**SECTION 96(1A) MODIFICATION APPLICATION SSD - 6724
60-78 REGENT STREET, REDFERN**

On behalf of Iglu Pty Ltd, we hereby submit an application pursuant to section 96(1A) of the *Environmental Planning and Assessment Act 1979* (EP&A Act) to modify State Significant Development Consent SSD 6724 relating to the construction of an 18 storey student accommodation building with retail space at ground floor at 60-78 Regent Street, Redfern.

60-78 Regent St  
Redfern  
East Elevation

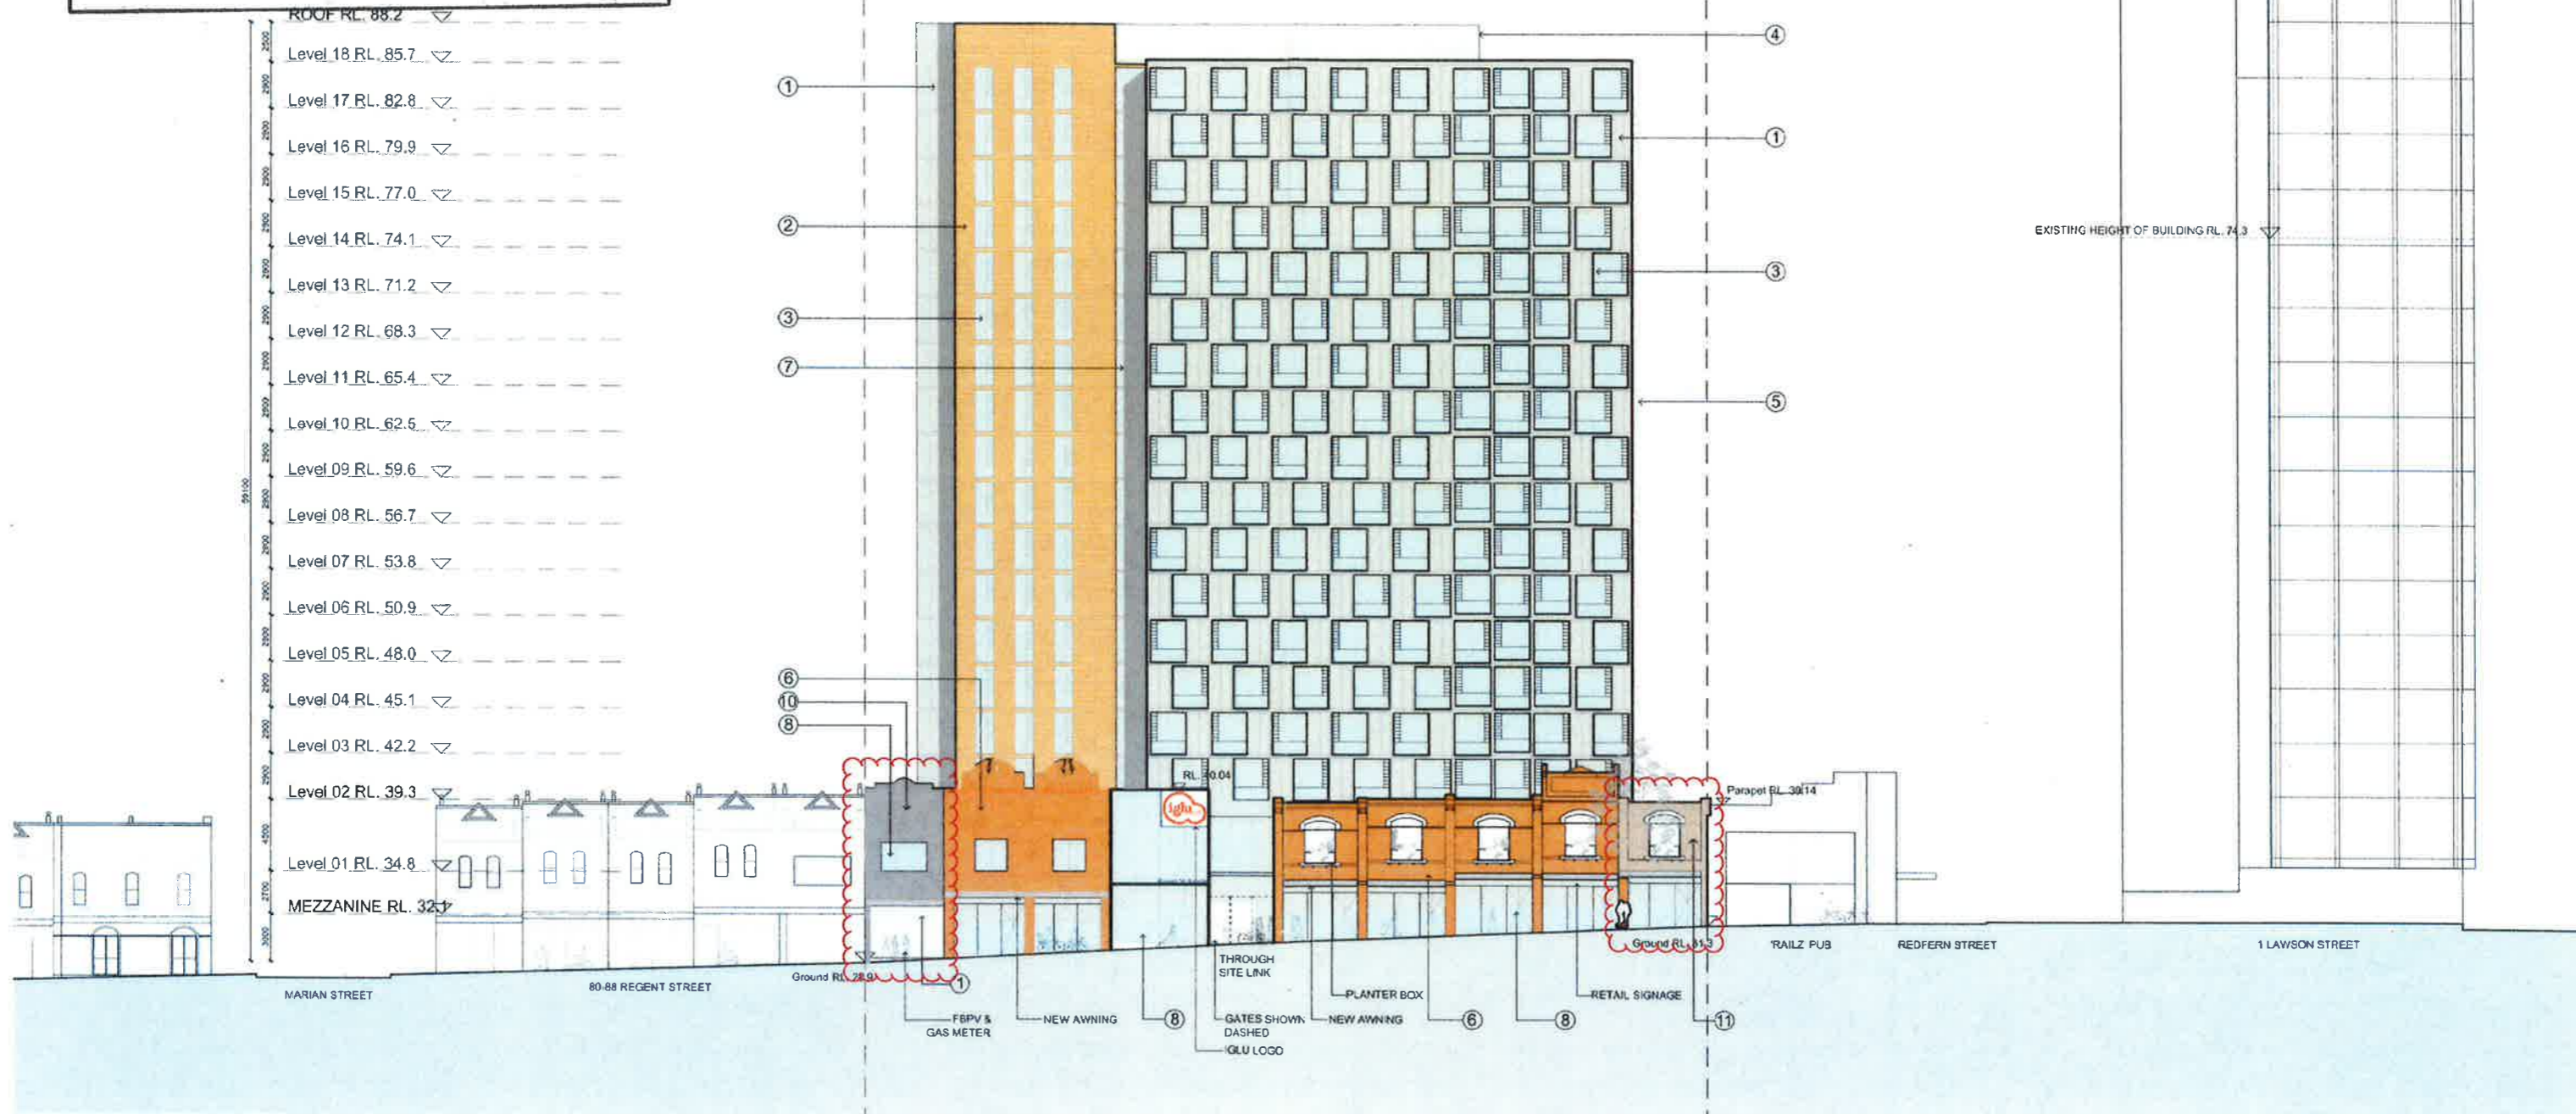
The proposed modification arises because on-site investigations have revealed that the existing brickwork to two of the original shopfronts have been rendered or bagged, preventing restoration of the face brick as shown on the currently approved plans. Accordingly, it is proposed that these two shopfronts will be repainted with neutral paint tones to be compatible with adjoining buildings and the broader streetscape.

It has become apparent during on-site construction investigations that the brickwork on two of these shopfronts has previously been rendered or bagged, and that the removal of these finishes to expose the face brick would not be possible without significantly damaging the bricks. As such, a face brick finish in accordance with the existing approved plan is not possible. A letter confirming this and providing photographic evidence has been provided by the appointed contractor, Richard Crookes Constructions (**Attachment A**).

Accordingly, it is proposed that the two affected shopfronts will instead be repainted with a neutral tone that is in keeping with the existing palette of adjoining buildings and the broader streetscape, as illustrated in **Figure 1**.

Plan revision number and date for the east elevation needs to be changed to reflect the updated plan that accompanies this Section 96 application.
